Application Reference: P/29/25/DOC Site Name: Land North of Hook Lane Pagham PO21 3PB	Initial Issue Date: 18/07/2025 Issue Date: 18/07/2025 Reviewer Reference: ADC/EXT2/D2134/73
--	--

Condition 9: **Further information required**

ADC Drainage Comments	Designer Response	ADC Drainage Comments	Designer Response	ADC Drainage Comments
Date:	12/07/2024				
Condition Number: 9 [Surface water Drainage Design]

ST1
(CLOSEST LOCATION TO TREES)
SCALE 1:20

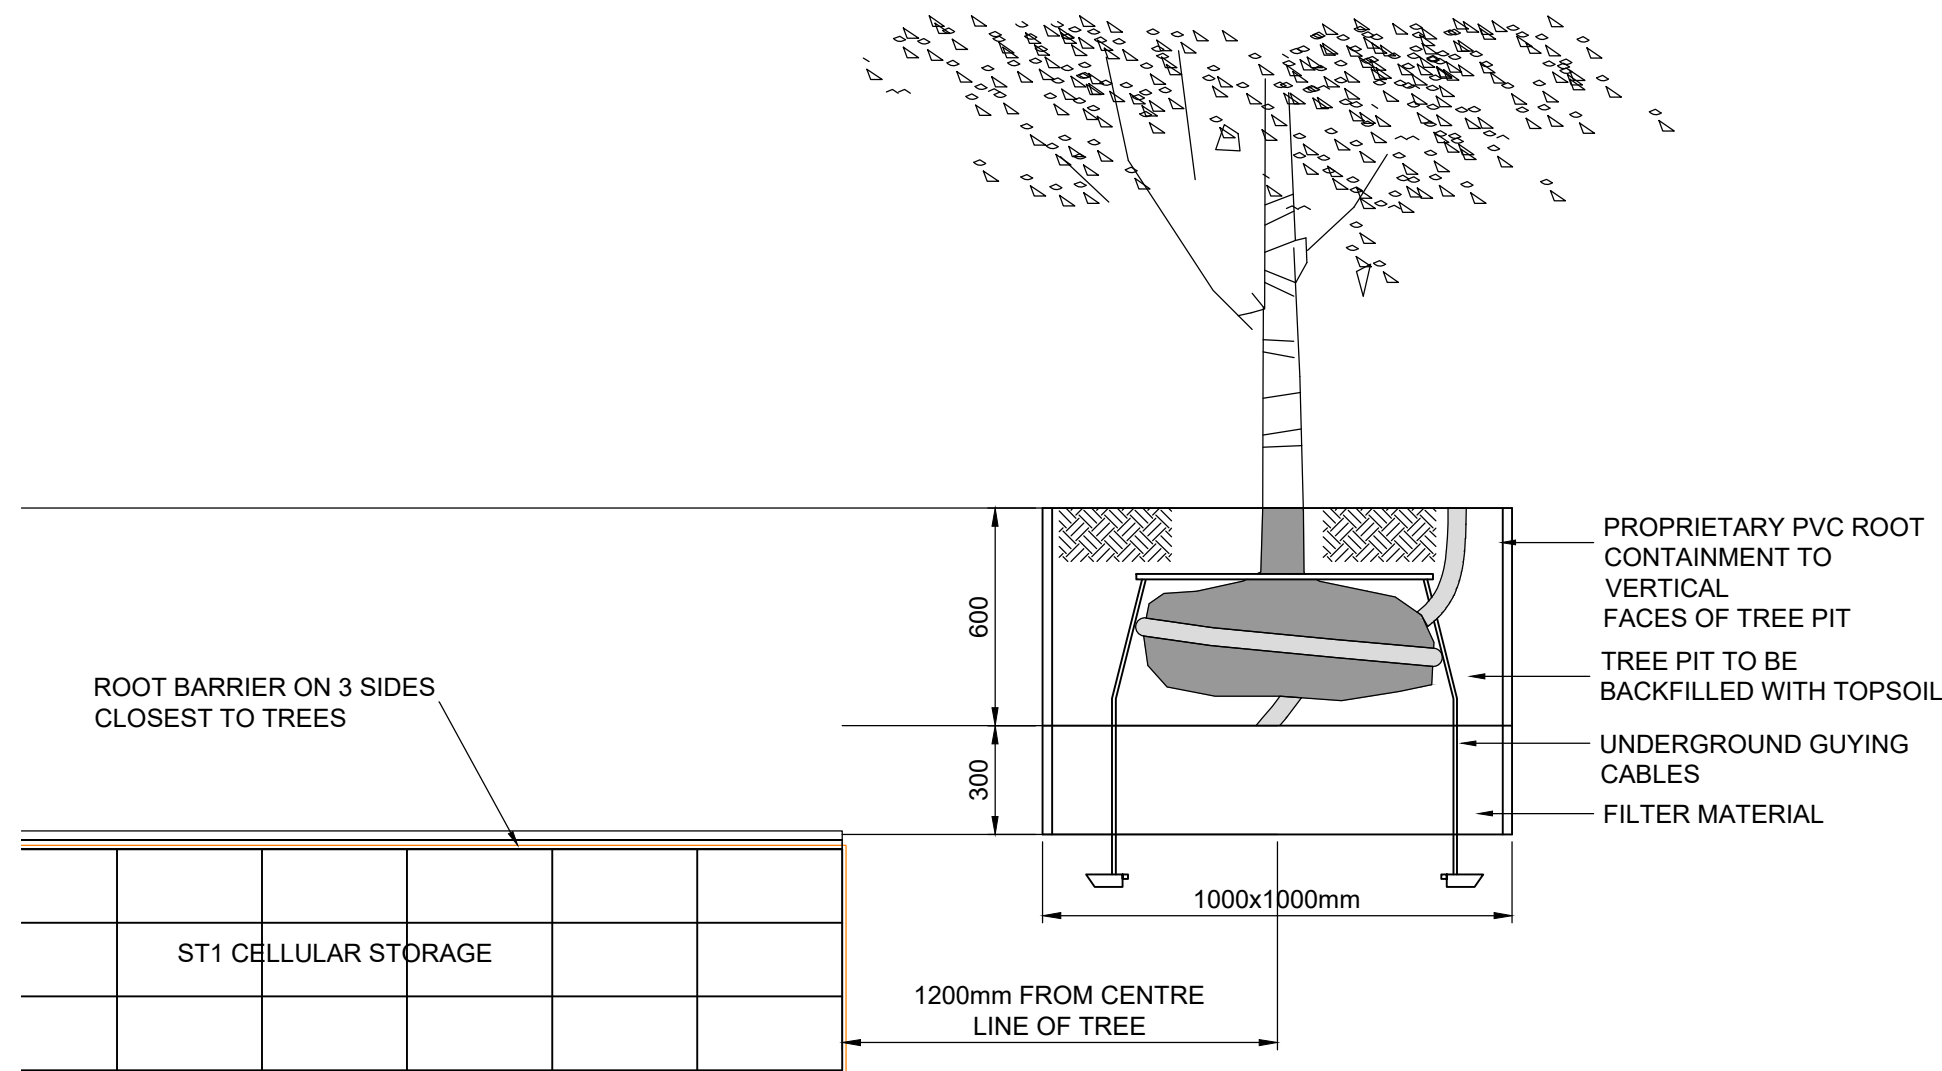
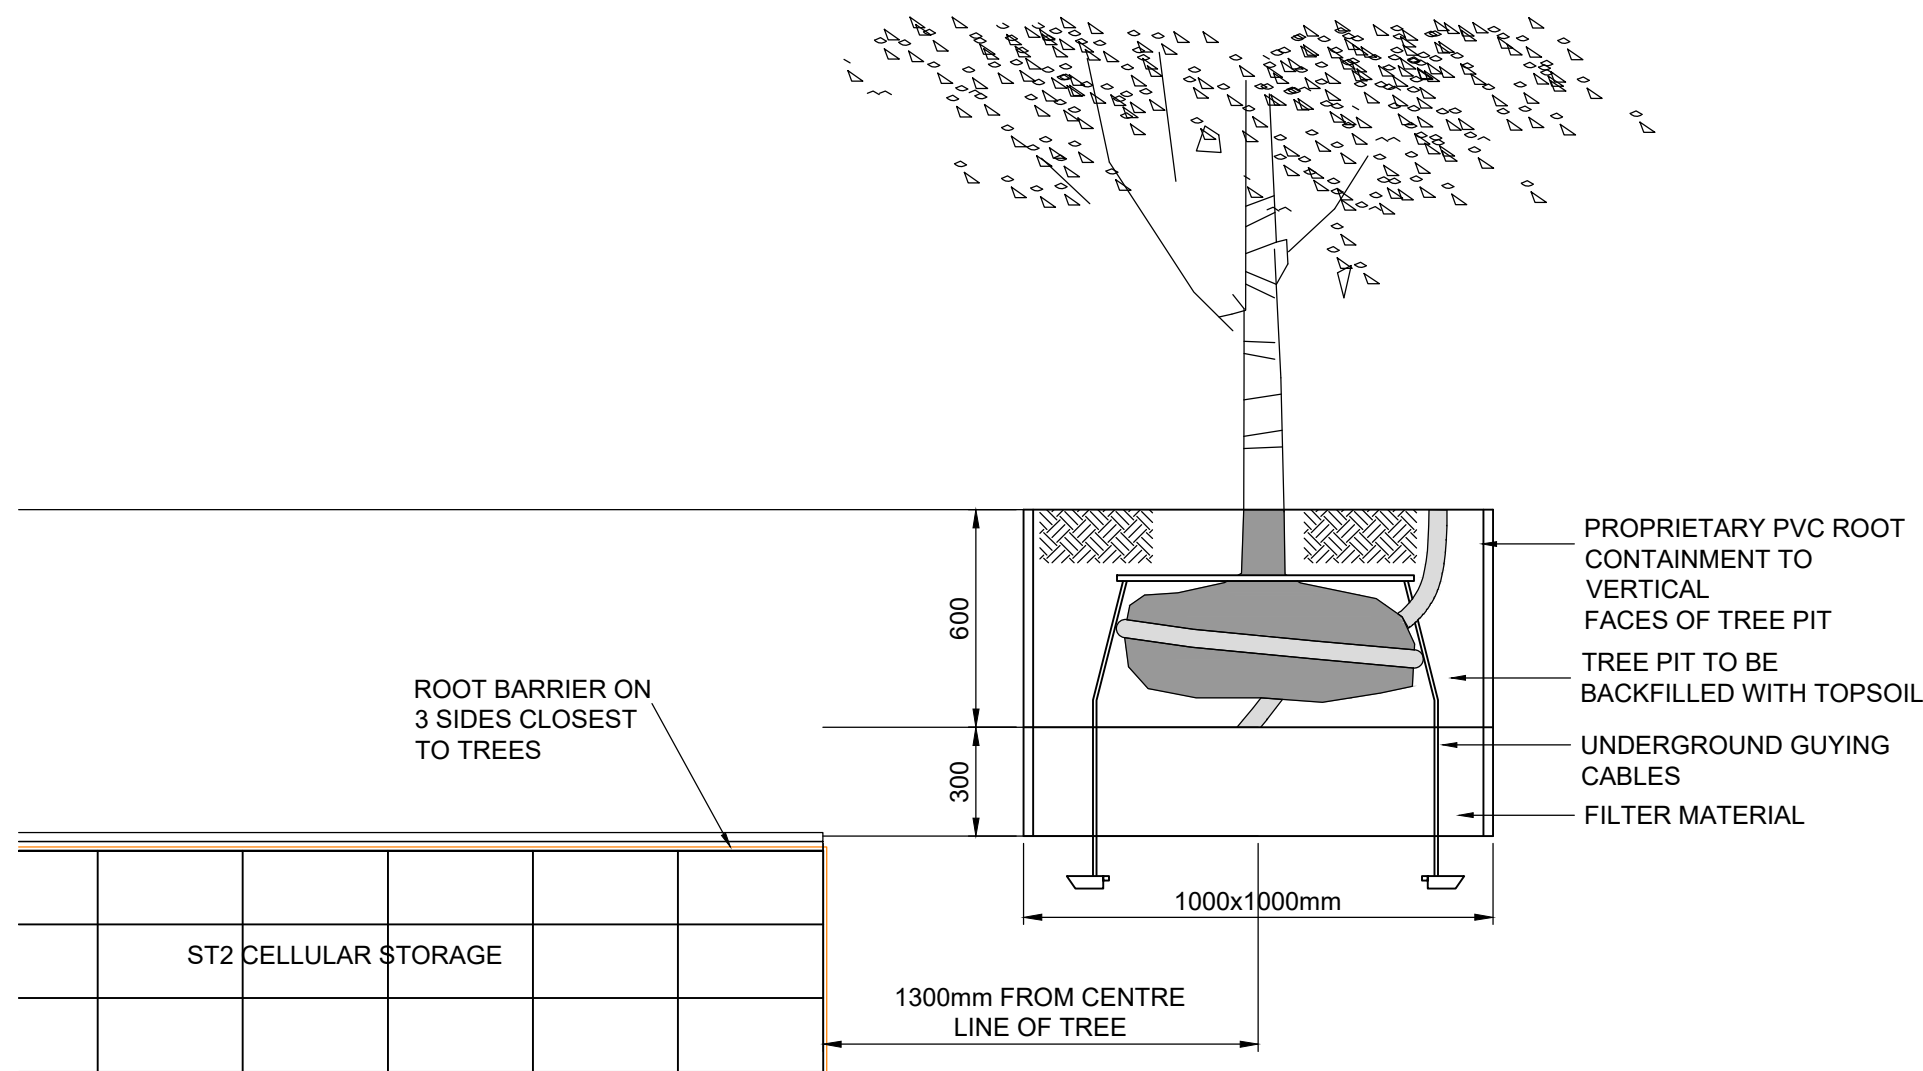
8.	Detailed landscaping proposals are required to demonstrate that the landscaping and drainage proposals are coordinated. a) The indicative landscape proposal drawing shows a tree very close to tank ST1. Section A-A provided does not appear to represent this.  b) Provide information from the root barrier manufacturer and the tank manufacturer that the proposal is acceptable. c) Demonstrate that the tanks are structurally sufficient given the close proximity of the trees.	A. Rev C Calculations - Updated Drawings & Calculations. B. See Appendix G. C. See Appendix G.
